KITTITAS COUNTY

MEMORANDUM

TO: All Staff
FROM: Public Works Plan Review Team
DATE: November, 6, 2025- UPDATE December 4, 2025
SUBJECT: SPF-25-00007 Sageview

SHEET 1 OF 4

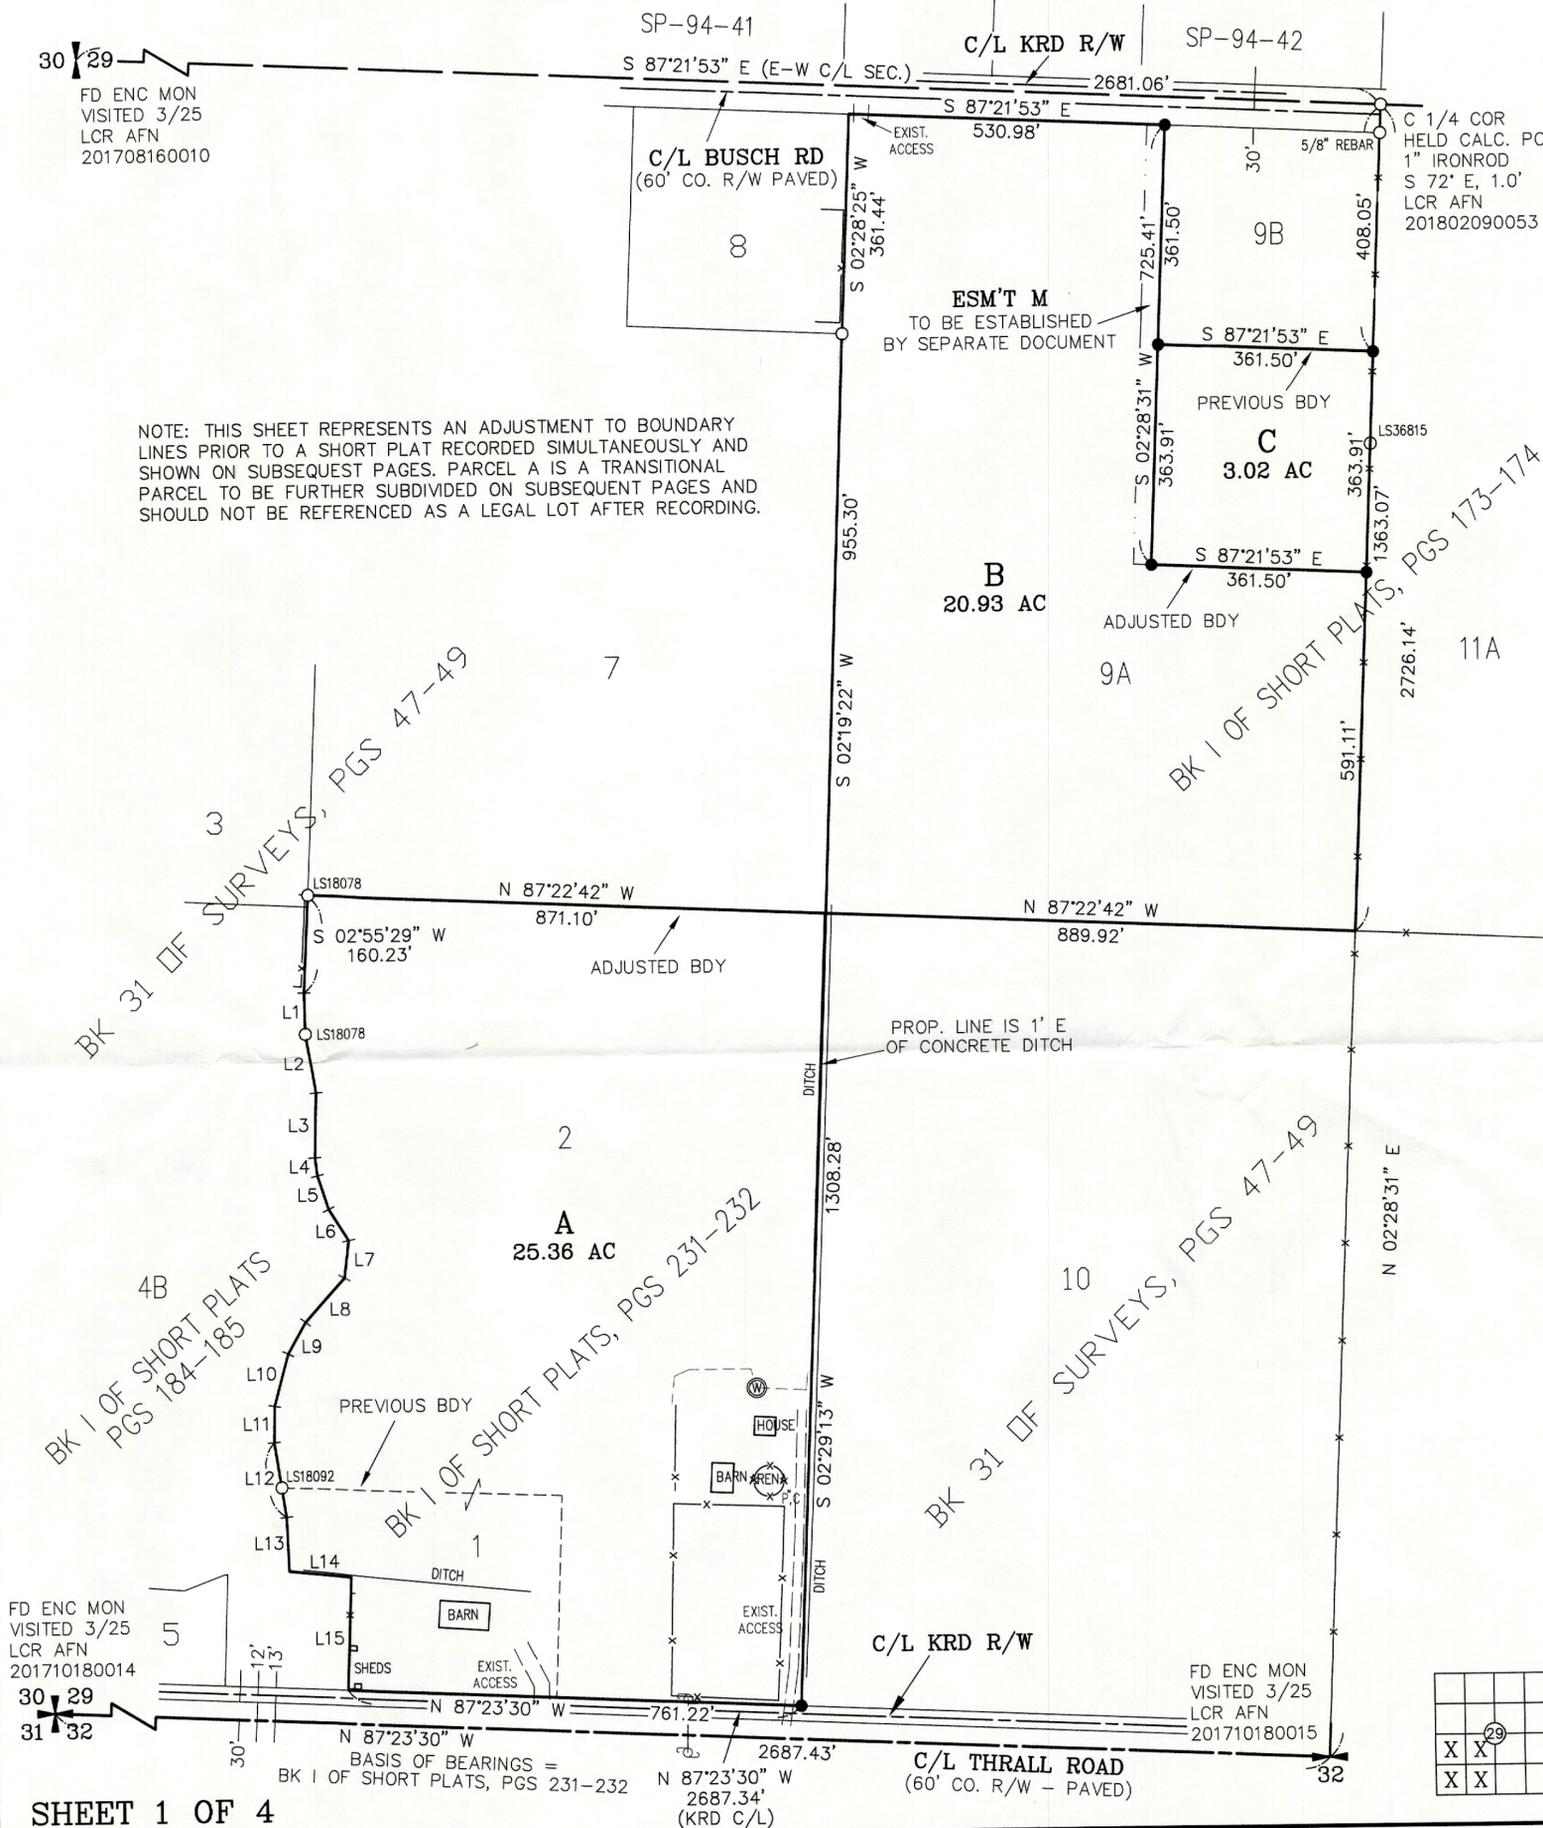
SURVEY	Clarify whether the bearing tie at the center of section is from calc position to found marker, or from found marker to calc position. (EX: Held Calc Position S72°E, 1.0' from Fnd 1" Iron Rod) or similar. OF NOTE Lot Closures were not provided as part of the review documents. Given the simplistic nature of the proposed boundaries, closure review not required. (JT) 12/4/2025 Update addressed survey concerns.
TRANSPORTATION CONCURRENCY	No transportation concurrency management requirements for this project. (KAH)
FLOOD	No comments. (SC)
WATER MITIGATION/ METERING	Water mitigation and metering requirements are satisfied for final plat approval. No additional comments. (SC)
AIRPORT	No Comments.(RC)

**SAGEVIEW SHORT PLAT**  
**PART OF SECTION 29, T. 17 N., R. 20 E., W.M.**  
**KITTITAS COUNTY, WASHINGTON**

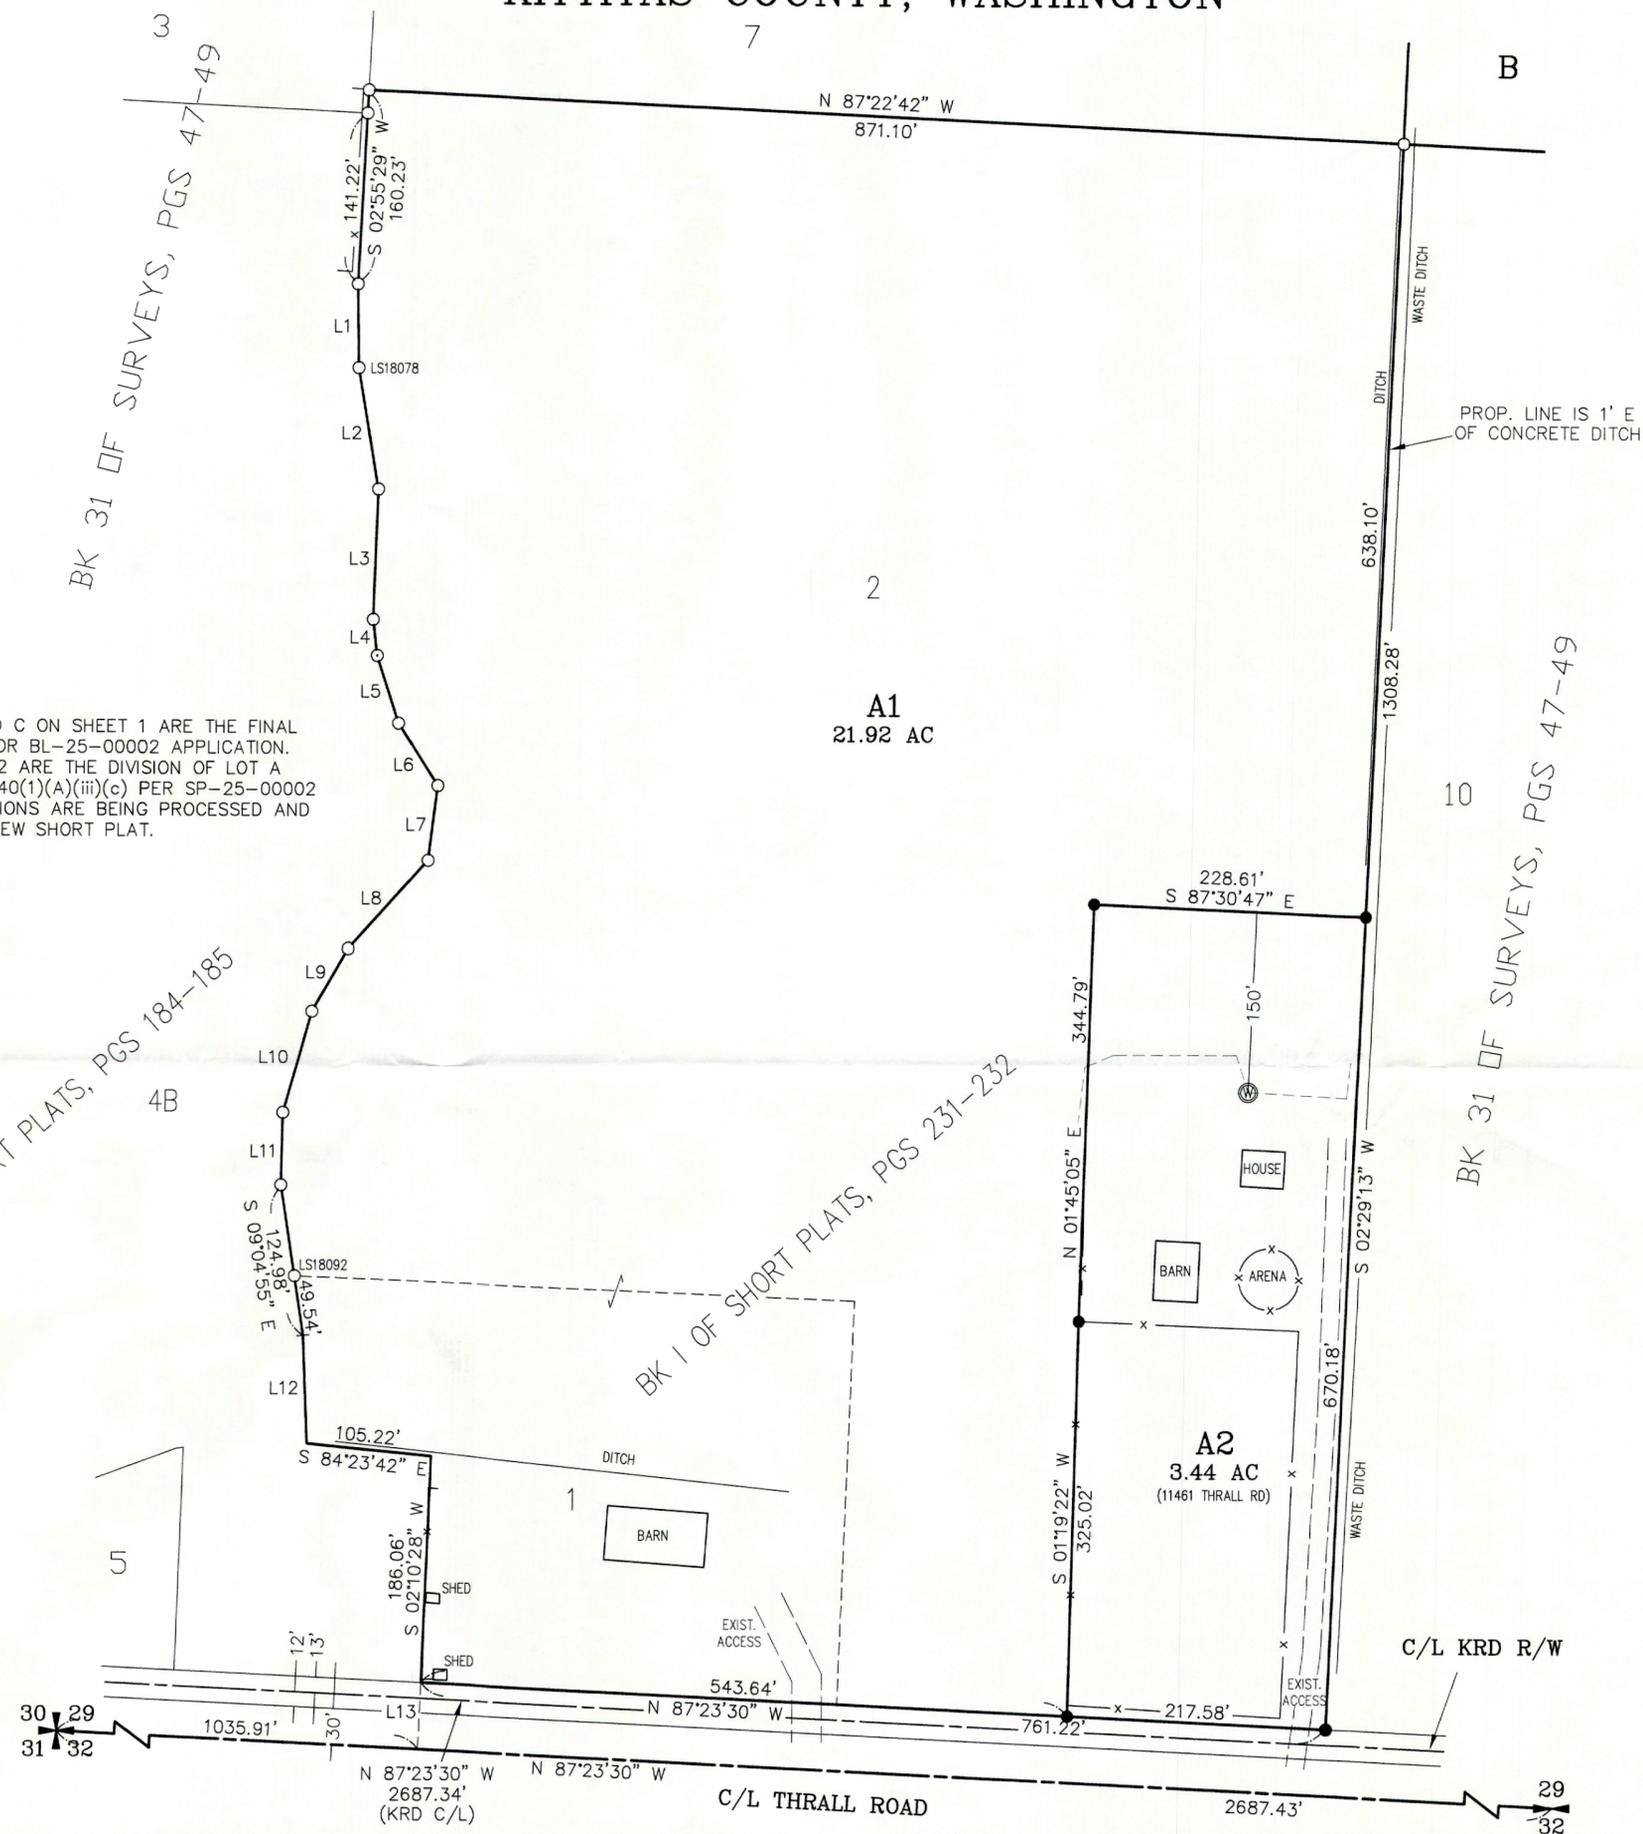
ACCESS	<ol style="list-style-type: none"> 1. An approved access permit shall be required from the Kittitas County Department of Public Works prior to creating any new driveway access or altering an existing access. 2. Maintenance of driveway approaches shall be the responsibility of the owner whose property they serve. The County will not maintain accesses. 3. Any further subdivision or lots to be served by proposed access may result in further access requirements. See Kittitas County Road Standards. 4. In addition to the above-mentioned conditions, all applicable Kittitas County Road Standards apply to this proposal. Access is not guaranteed to any existing or created parcel on this application. 5. Please show "Easement M" with a minimum of 30' width for purpose of access to Lot C. <p>Of Note: Please ensure that Lot A retains the address of 11461 Thrall Rd upon final recording of short plat. (RC)</p> <p>UPDATE 12/2/2025 Access for lot C and 9B will be limited to a joint-use access "Easement M" with no additional access allowed.</p> <p>Description of Easement M does not match location of easement on survey that is shown affecting lot B.</p>
